CITY OF PORTLAND, MAINE  
DEVELOPMENT REVIEW APPLICATION  
PLANNING DEPARTMENT PROCESSING FORM

single family w/ att garage

87 Garsoe Dr, Lot # 9

**DRC Conditions of Approval**

PLOT PLAN
OF:
LOT 9 AUBURN PINES SUBDIVISION
AUBURN PINES DRIVE
PORTLAND, ME
FOR:
NORMAND BERUBE BUILDERS, INC.
1040 U.S. RTE 1
SACO, ME 04072

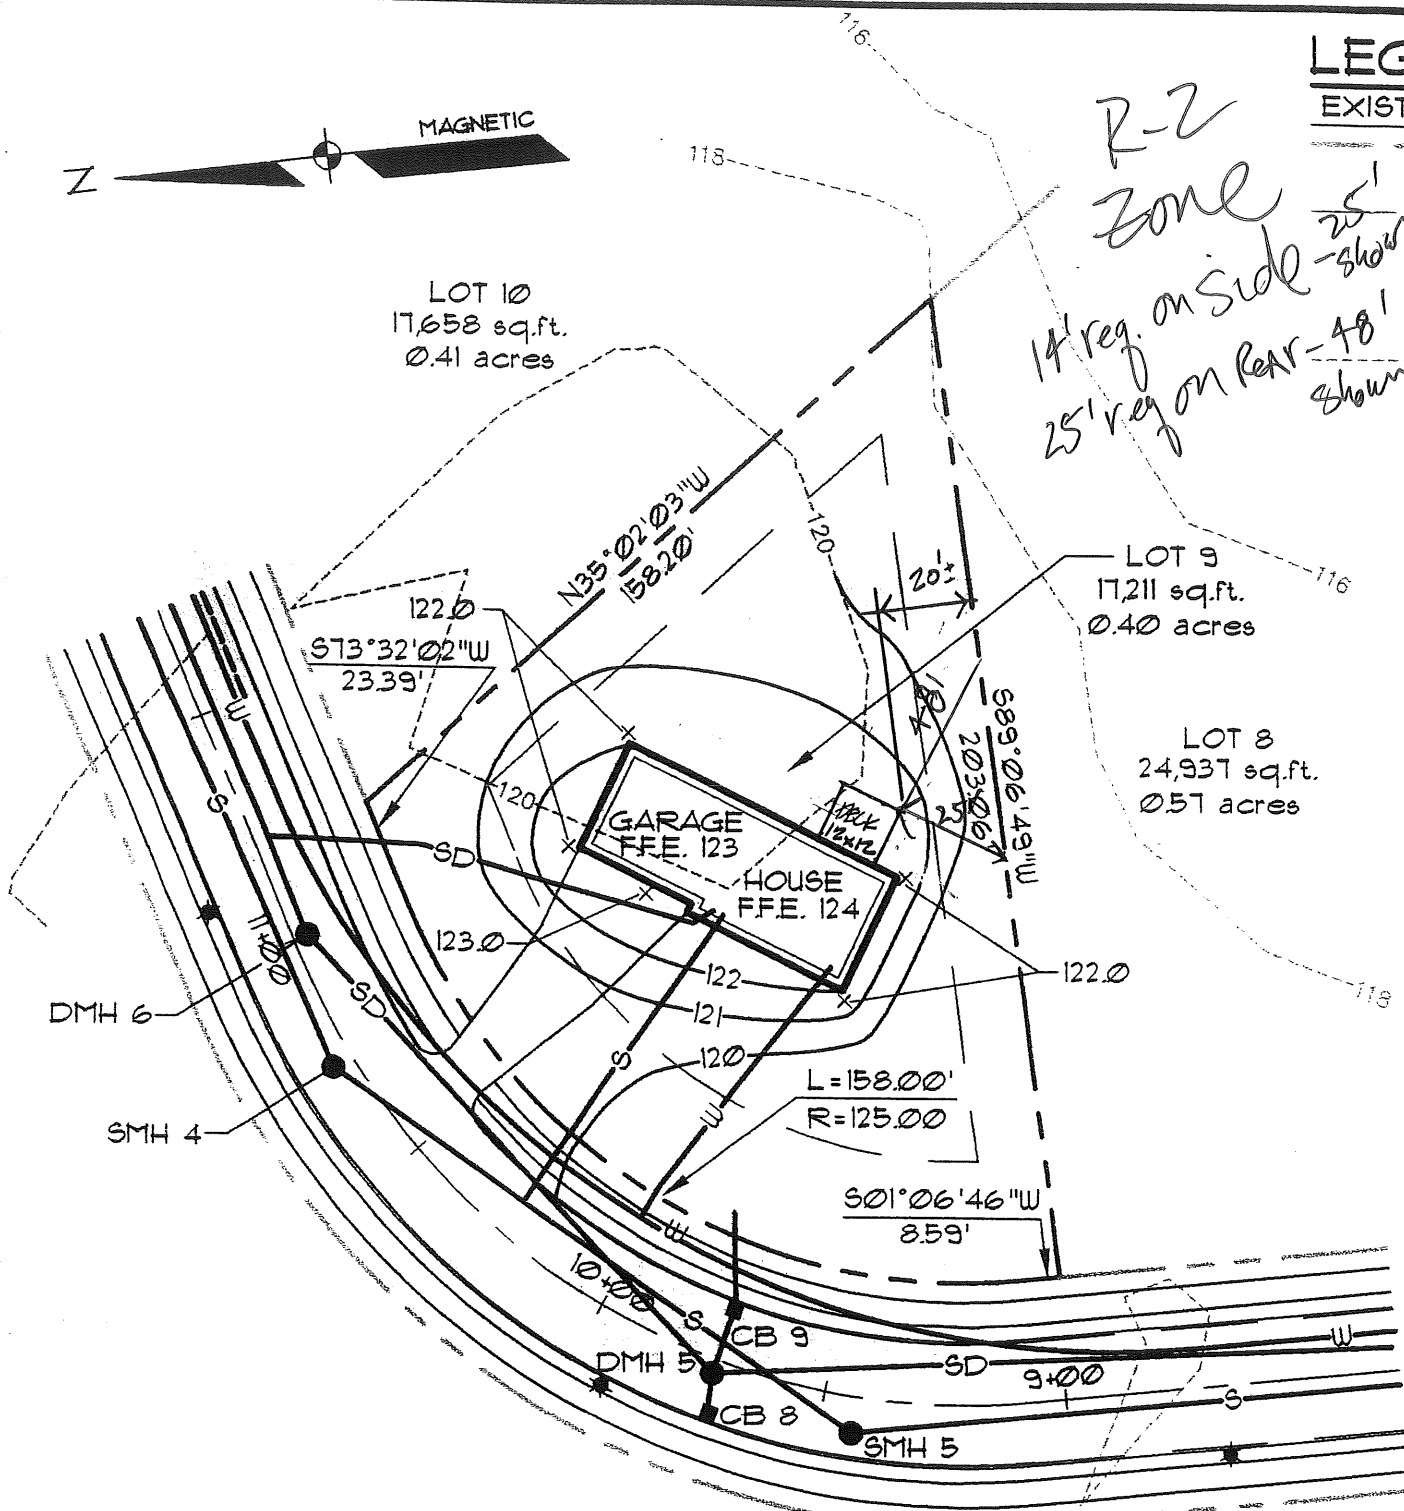
Show all utility connections: water, sanitary, sewer, storm drain, electric, telephone, cable.

A drainage plan shall be submitted to and approved by Development Review Coordinator showing first floor elevation (FFE), sill elevation (SE), finish street/curb elevation, lot grading, existing and proposed contours, drainage patterns and paths, drainage swales, grades at or near abutting property lines, erosion control devices and locations and outlets for drainage from the property.

Per sheet C3 of the original subdivision plans, lot 9 was to have been the location of a temporary stock pile. If necessary, the applicant shall relocate any stock piles to an alternative location. The grading plan shall be revised to direct runoff from the disturbed area of the lot towards the street. The applicant shall refer to sheet P1 of the Auburn Pines subdivision plans for the street grades. The applicant shall be responsible to avoid drainage impacts to abutting properties.
